Your Ref: OWPC25699
Our Ref: R/15/20/CLP 20-01-2020
Please ask for:
Zac Denton

Application for Certificate of Lawfulness for a Proposed Use - rear dormer & front velux
3 Dolphin Way Rustington

Thank you for your internet representation made on 7th February 2020 which has been recorded as '**an objection**' with the comments as follows:

Proposed Elevations 3 Dolphin Way, Rustington

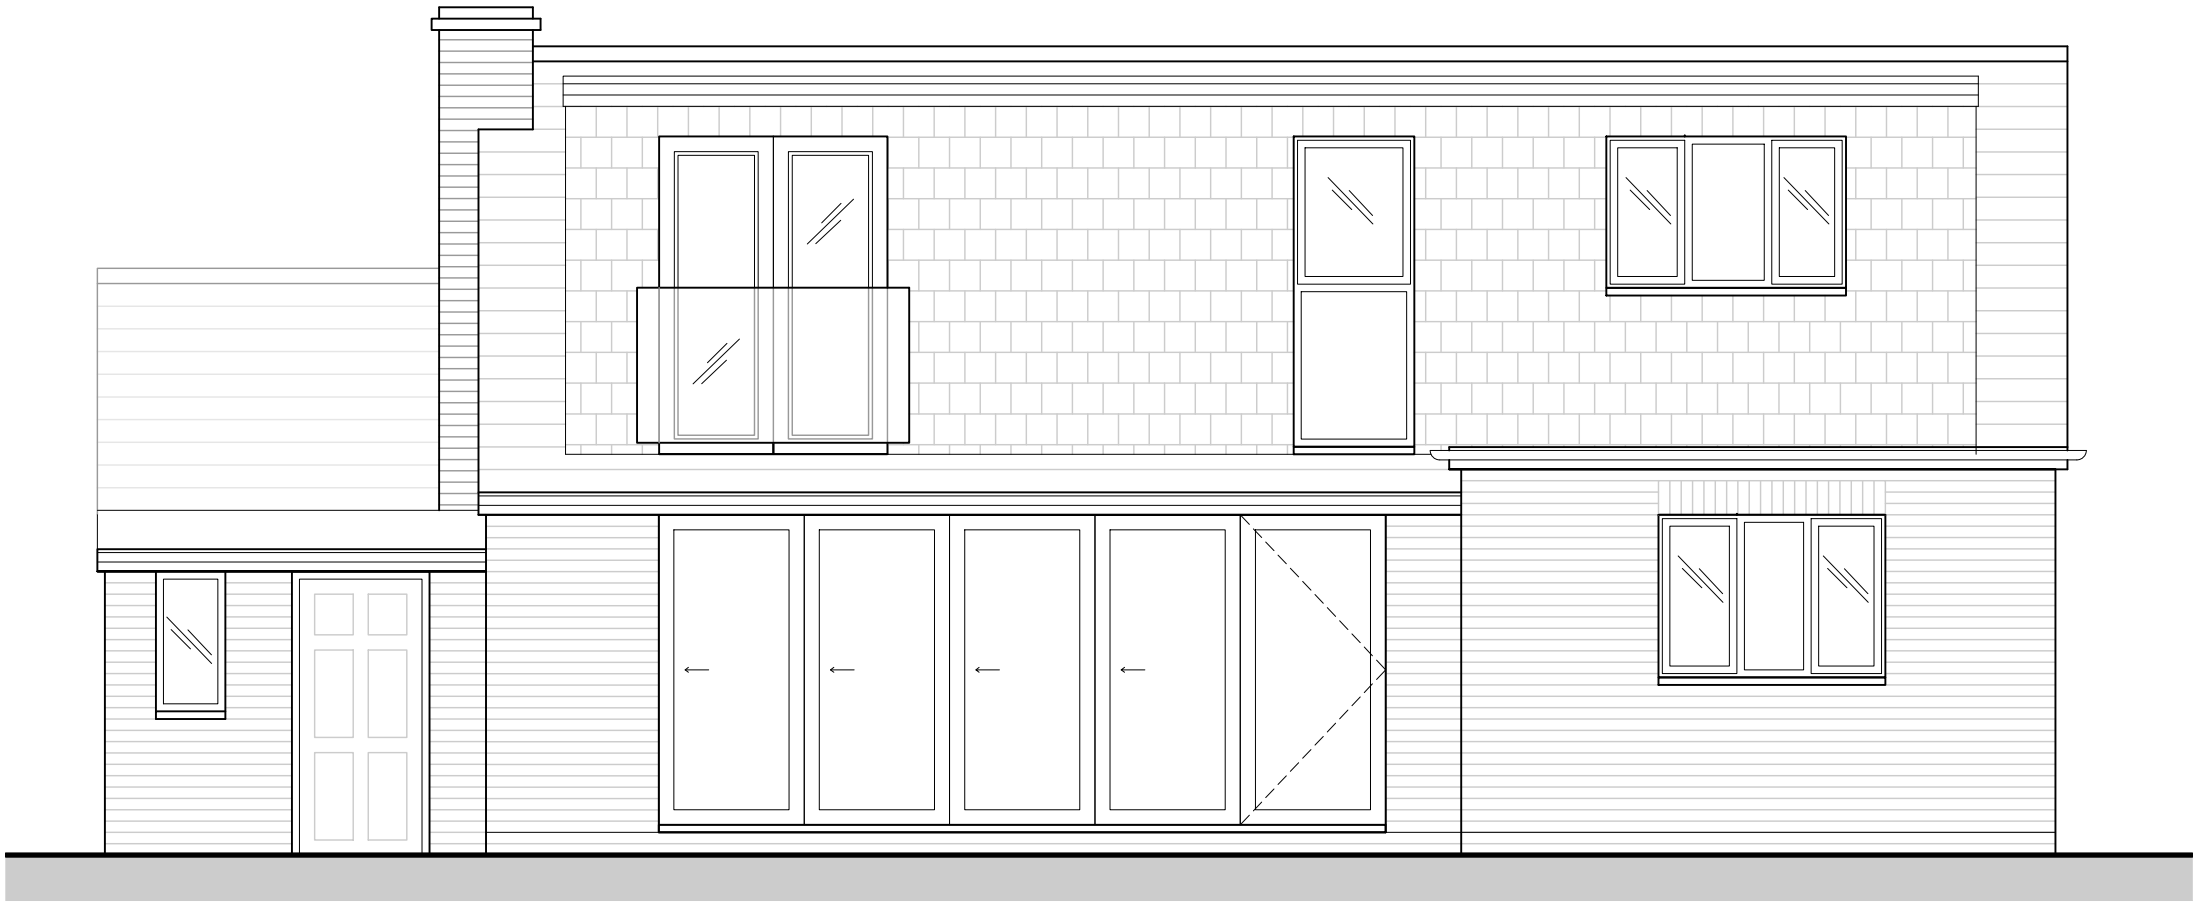
On viewing the plans, more particularly proposed elevations drawing no. A030, we are very concerned about the impact upon us. The three new windows in the dormer, facing east, are directly overlook our property and as a consequence lead to a complete loss of privacy. The environment that we have lived in for the last 36 years is being completely altered by the building. The new windows in the development look directly into our lounge, bathroom, study and kitchen and overlook the garden. Since the building works have already started we have been able to take a number of photos which clearly show the loss of our privacy. We are happy to provide these if required.

I would respectfully draw your attention to the decision made on 8th January 2007 relating to our application ref. no. R/305/06. Condition 2 attached to that decision ruled out any windows overlooking the property to the north. I would expect consistency in your decision on R/15/20/CLP.
